Arun District Council
Arun Civic Centre
Maltravers Road
Littlehampton
West Sussex BN17 5LF
Planning & Building Control General Enquiries
Tel: (01903) 737756 Fax: (01903) 730442
Dx: 57406 Littlehampton
Minicom: 01903 732765
e-mail: planning@arun.gov.uk
website: www.arun.gov.uk/planning

Application No: AB/130/21/HH
Site Address: 55 Fitzalan Road Arundel BN18 9JP
Description of works: Erection of single storey rear extension. First floor extension and front facing dormer. Porch to front.

Thank you for your internet representation made on 1st December 2021 which has been recorded as an objection with the comments as follows:

Drawing P10a October 2021 Scale 1:100 & 1:1250 @ A3
Planning Drawing - Floor Plans, Elevations & Location Plan

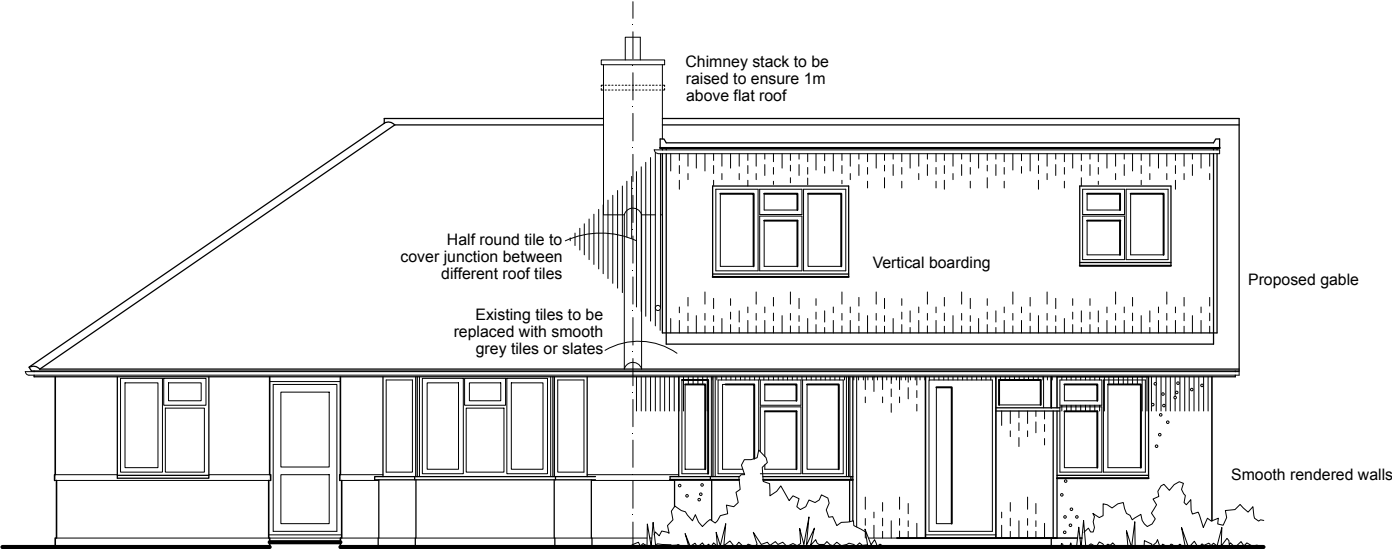
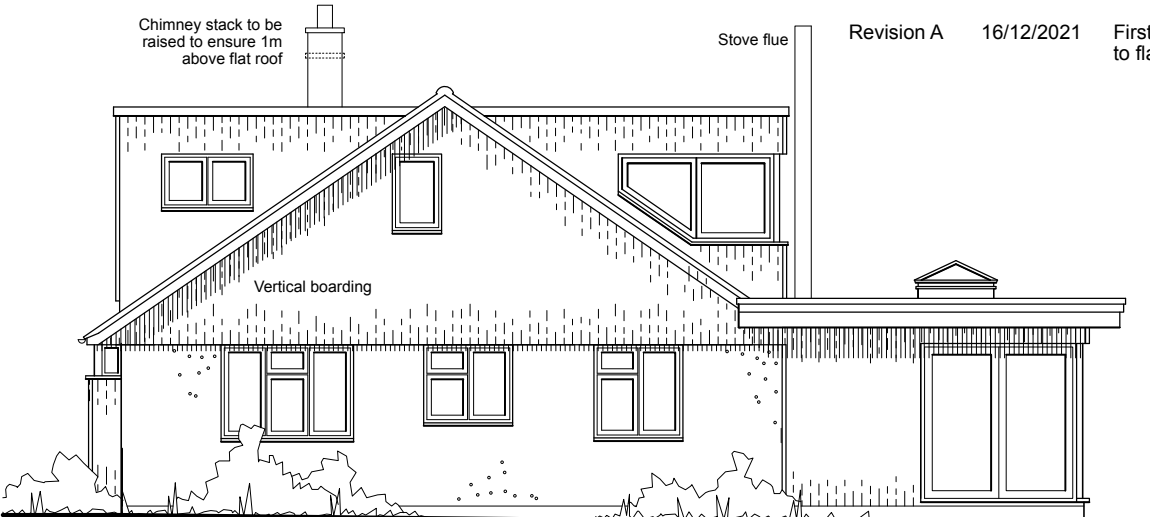
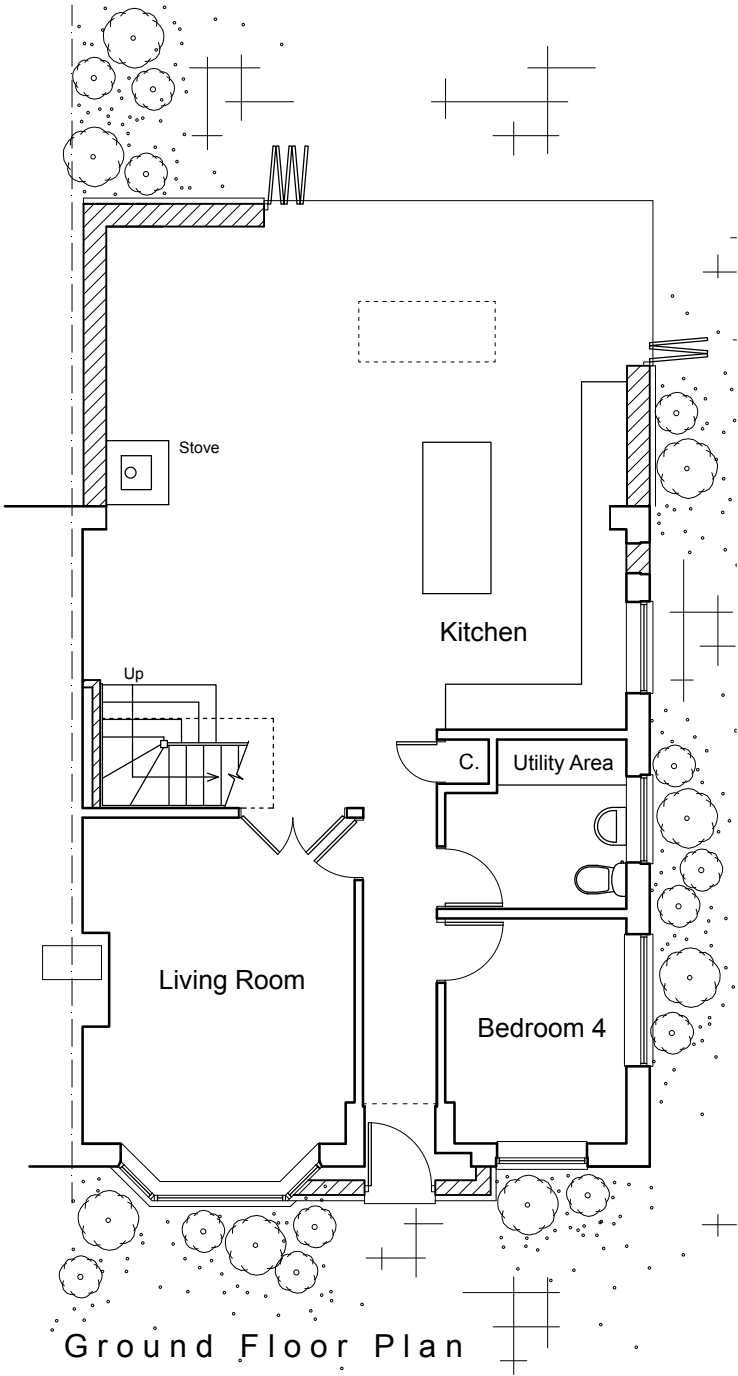
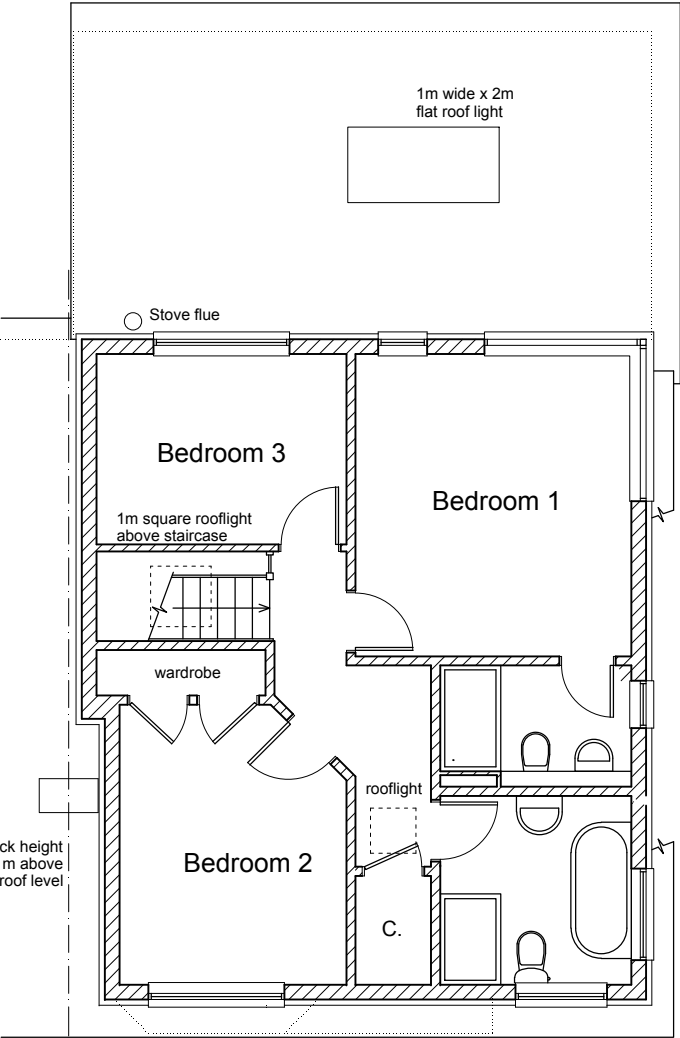
The Committee objected to this application on the grounds that the proposed extension is not sympathetic to the existing building, particularly in size and the proposed materials are not in line with policy DM4 of the Arun Local Plan, nor is it in keeping with the street scene of Fitzalan Road.
